Appendix D: Response to Agency Submissions

Issue Raised	Response
NSW Department of Planning and Environment	
Consideration should be given to how the approved Stage 1 retail and club facilities could be integrated with the proposed additional uses and envelopes to enhance the town centre qualities of the development.	The proposed modification provides for two new uses within the Eastern Precinct – residential and the hotel. The co-location of these uses will give rise to significant benefits in terms of activation of the centre throughout the day and evening. The amended Design Report prepared by Turners (Appendix B) provides additional detail regarding the access and circulation arrangements which will ensure that residents can easily access the other uses within the centre whilst retaining a sense of privacy from public uses with clearly delineated public access, resident access and communal spaces. This integration and separation will ensure that a successful and functional outcome is achieved which delivers a high-quality town centre experience for future residents and visitors.

level 4 landscape planter & "Greenwall". Precedent Images

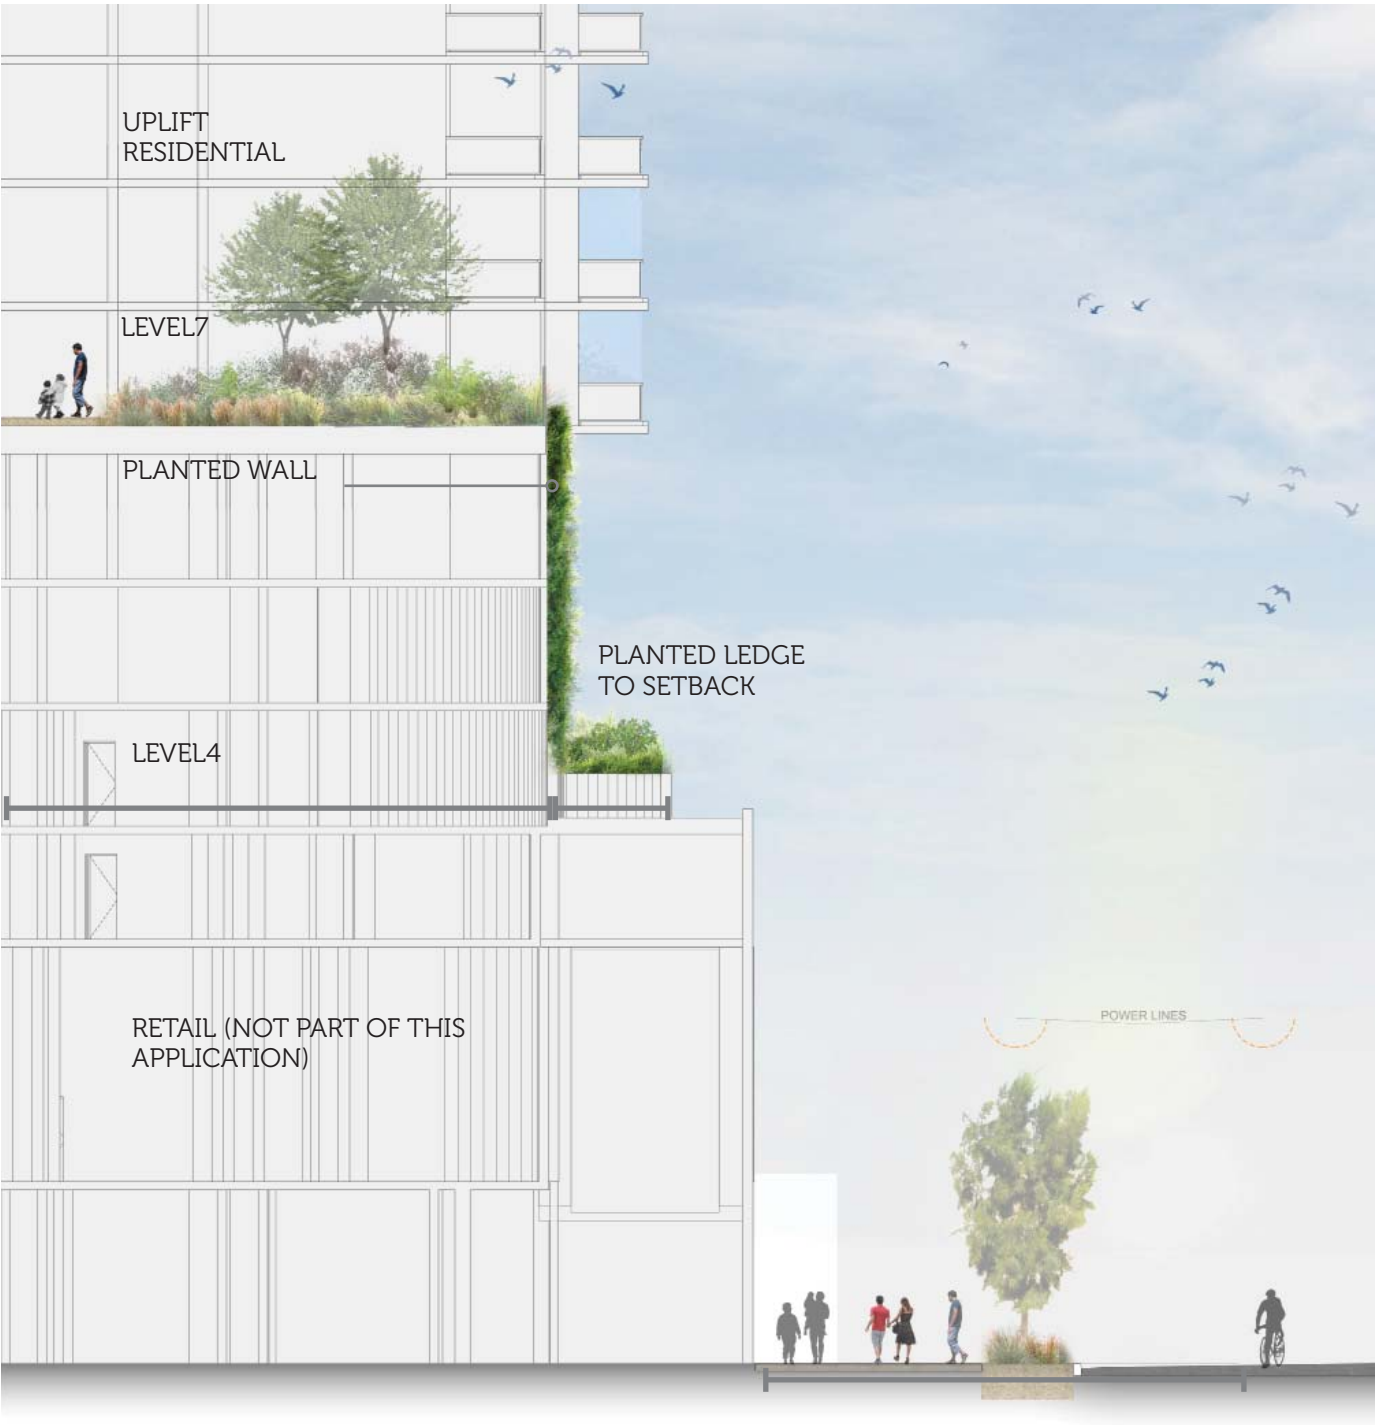
<p><i>Level 3 Elevated Street</i></p> <p>Plans approved under the original proposal indicate extensive landscaping associated tree planting within the elevated street on Level 3. Unfortunately, this appears to have been significantly reduced to support more sky lights and pedestrian paths. Ideally opportunities should be sought to increase canopy cover where possible to offset the bulk and scale of the development, to provide shade, and to improve the entry sequence into the Club from the car park.</p>	<p>The design of the Level 3 street has responded to the modified context of the development and has sought to provide amenity through a balance of landscaping and design elements. Increasing sunlight into the shopping centre and providing pedestrian paths are considered critical for the useability of the centre. Landscaping and significant trees remain a part of the Central Roadway and opportunities will be sought to maximise amenity as part of detailed design.</p>

Landscape Concept Plan | Level 07

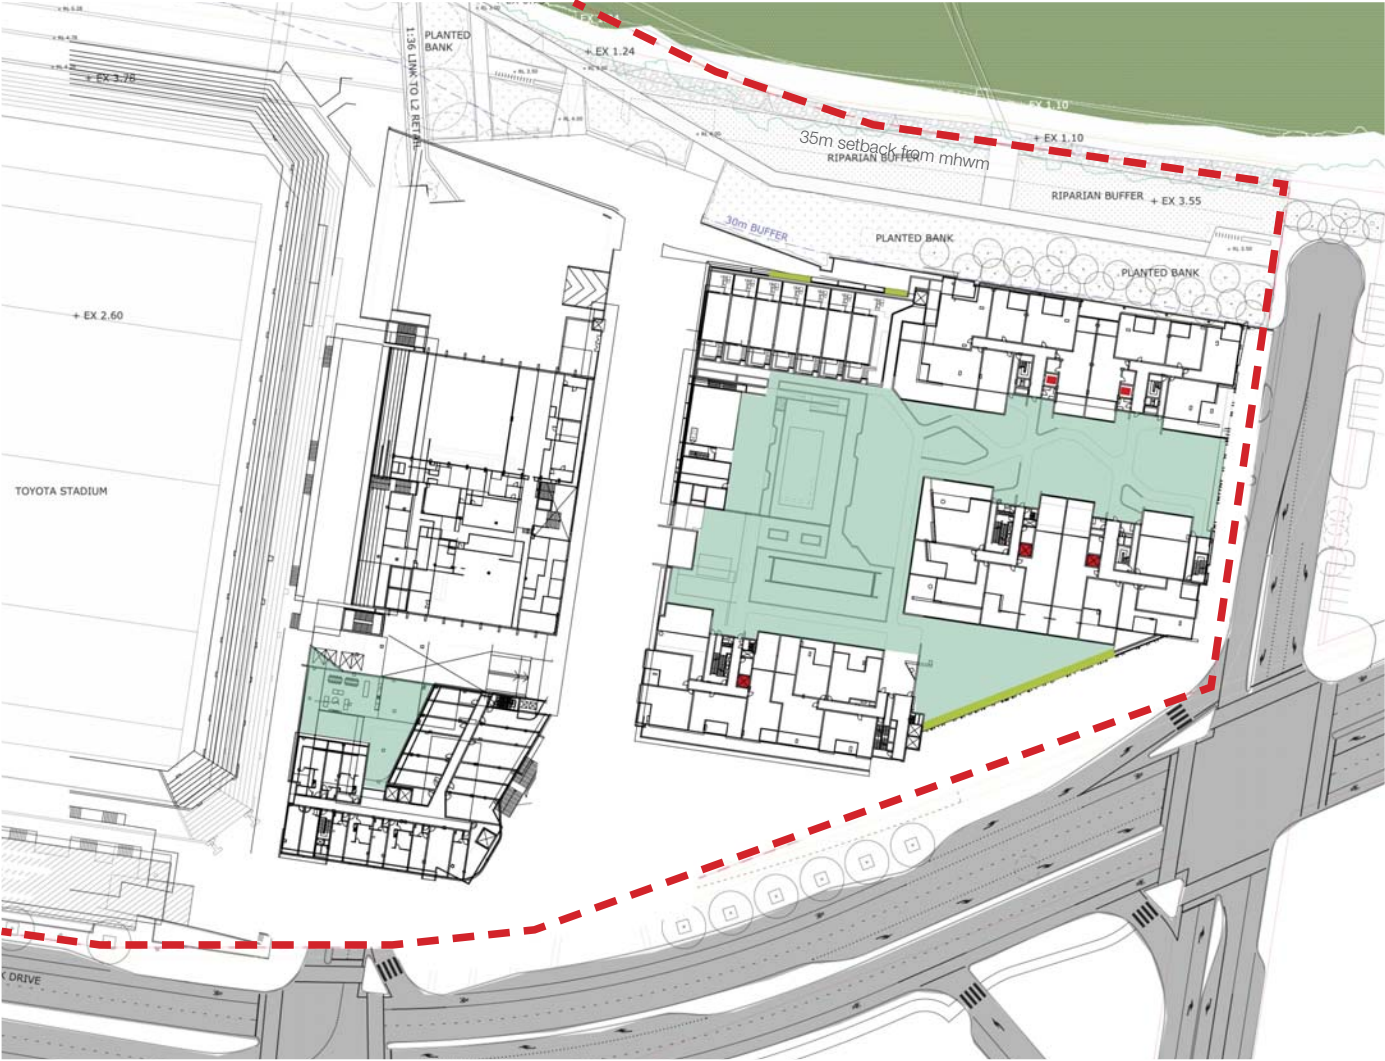
Issue Raised	Response
<p><i>Level 7 Rooftop Communal Open Space</i></p> <p>Planting areas to support trees on the Level 7 rooftop area should be achieved through a combination of setting planting down within the floor slab, raised planter boxes and raised paths. Mounding alone is not supported. More detailed information (in the form of cross sections and elevations) should be provided to show how and where this will be achieved.</p>	<p>Noted. This information is most appropriately provided as part of a future detailed development application.</p>
<p><i>Species Selection</i></p> <p>In addition to being located within close proximity to an Endangered Ecological Community (Estuarine Swamp Oak Forest) - the subject site is located within a Greenweb Support Area. All new tree plantings and 80% of understorey plants should ideally be indigenous species.</p> <p>Species such as Liriope muscari/spicata, Raphiolepis indica, Lomandra hystrix and Pennisetum alopecuroides are weeds (Sydney Weeds Committee, 2012) and must not be included.</p>	<p>Noted. Tree plantings will be selected to be consistent with Council's specifications.</p>
